Application number: 2023/92409	
What is the application for?:	Demolition of garages/storage units and erection of detached dwelling
Address of the site or building:	garage site, off Bradley Road, Bradley, Huddersfield, HD2 1XD
Postcode:	WF17 9PH

Type of comment: An objection	
Do you wish your comments to be published on the website anonymously?	Yes
I wish to lodge my objection to the request for planning detailed in application number 2023/62/92409W. The size of this proposed property is unsuitable for the size of the area and is definitely not within keeping with the properties around it, all of which are stone terraced houses. This dwelling will have a significant impact on the existing properties causing issues with light and privacy for the residents of both Upper Quarry Road & Bradley Road, some of which occupy back-to-back properties. The raised decking area is raised over 6ft and is overlooking both gardens and properties on Upper Quarry Road which again creates a loss of privacy to these properties. When planning was granted for the current development (Application Numbers 2016/60/91688/W & 2019/61/91707/W), the planning subcommittee noted that properties to be built in li

**PROPOSED SITE LAYOUT**  
Scale 1:200

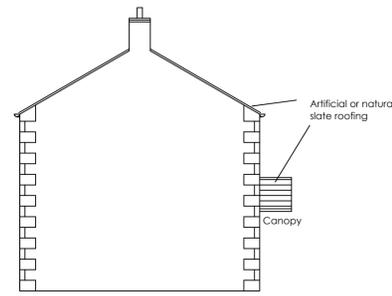
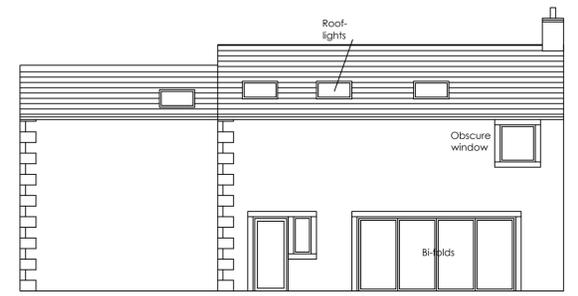
The plans that have been submitted are including land that does not belong to the landowner of this plot/proposed house. The plans /drawings have already had to be amended as they included the garage of 34 Bradley Road. The plans that are still online include land that belong to the owner of the Bradley Meadows Development, this means that the plans online for this proposed house must be inaccurate.
